Crystal Park Site S-229(R), CP-22-2

Please accept the following comments from El Paso County Public Health regarding the project referenced above:

SITE PLAN

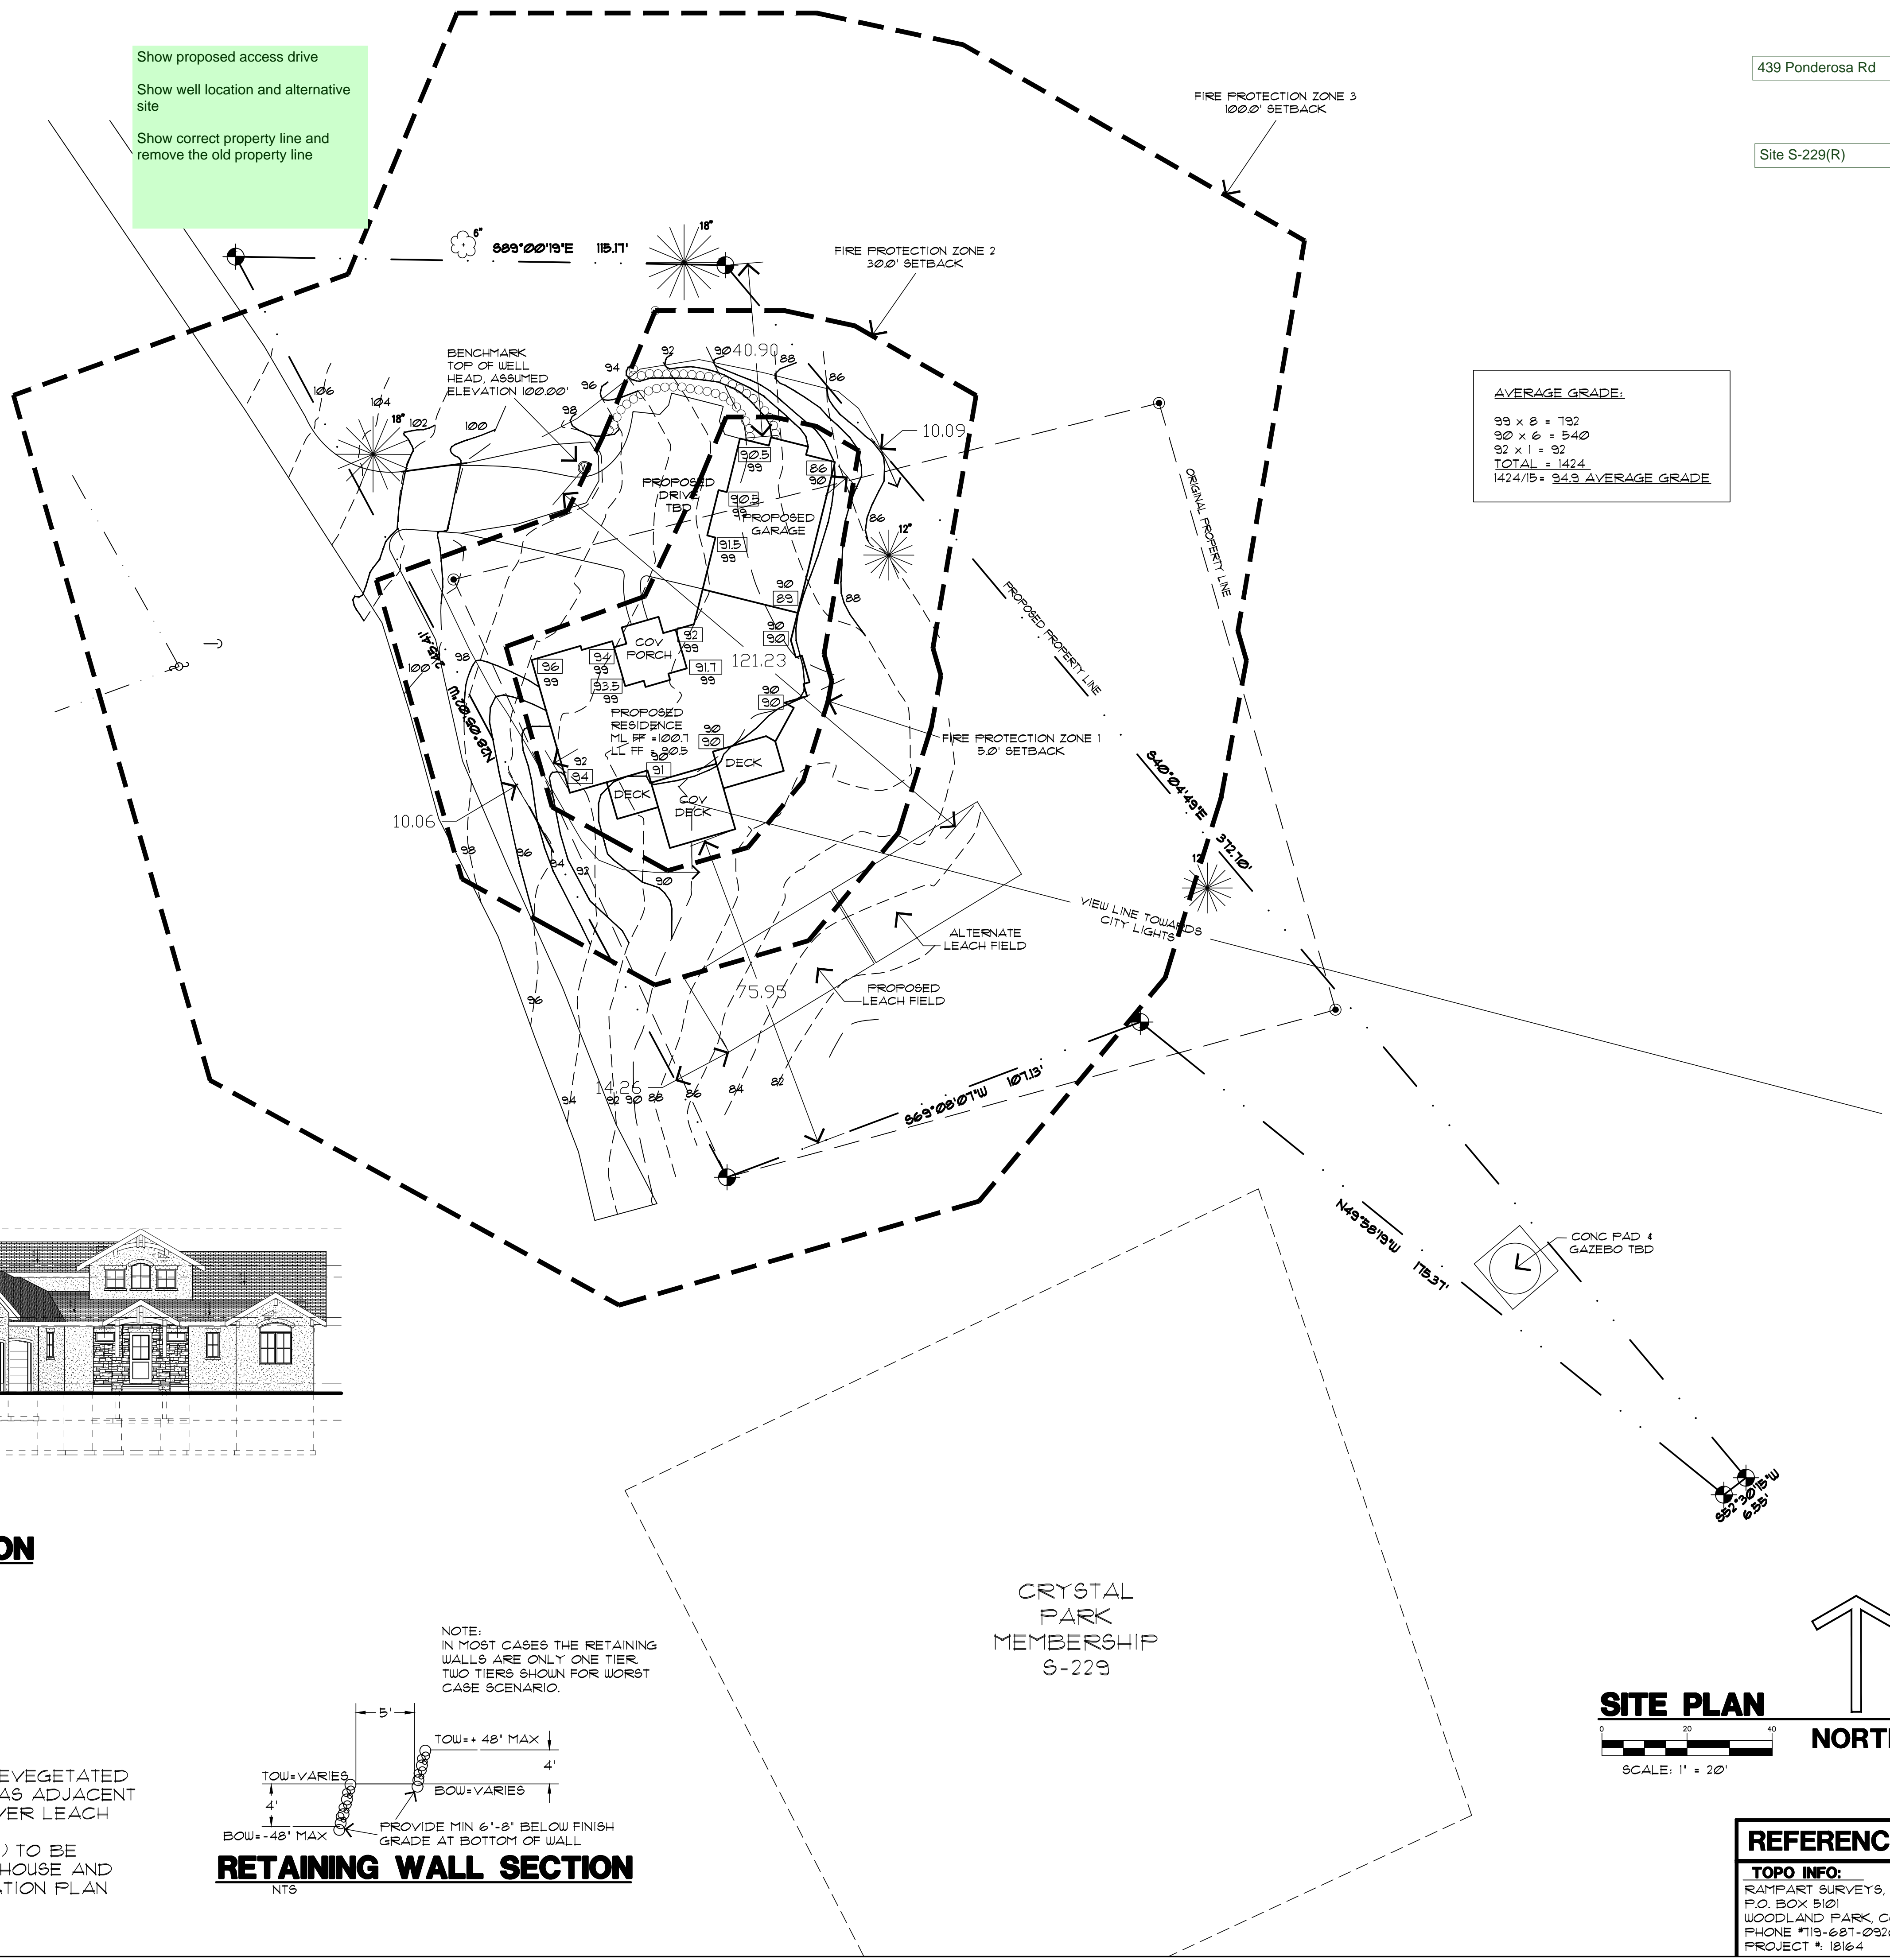
- **Crystal Park Site S-229(R), 439 Ponderosa Road, is an undeveloped residential site that will be served water by an individual private well and wastewater through an on-site wastewater treatment system (OWTS).**
- **Construction activity for the house could cause compaction of the proposed soil treatment areas (STA). The STA's must be located and protected from compaction.**
- **The onsite wastewater treatment system must comply with all El Paso County Public Health rules and regulations for OWTS's.**
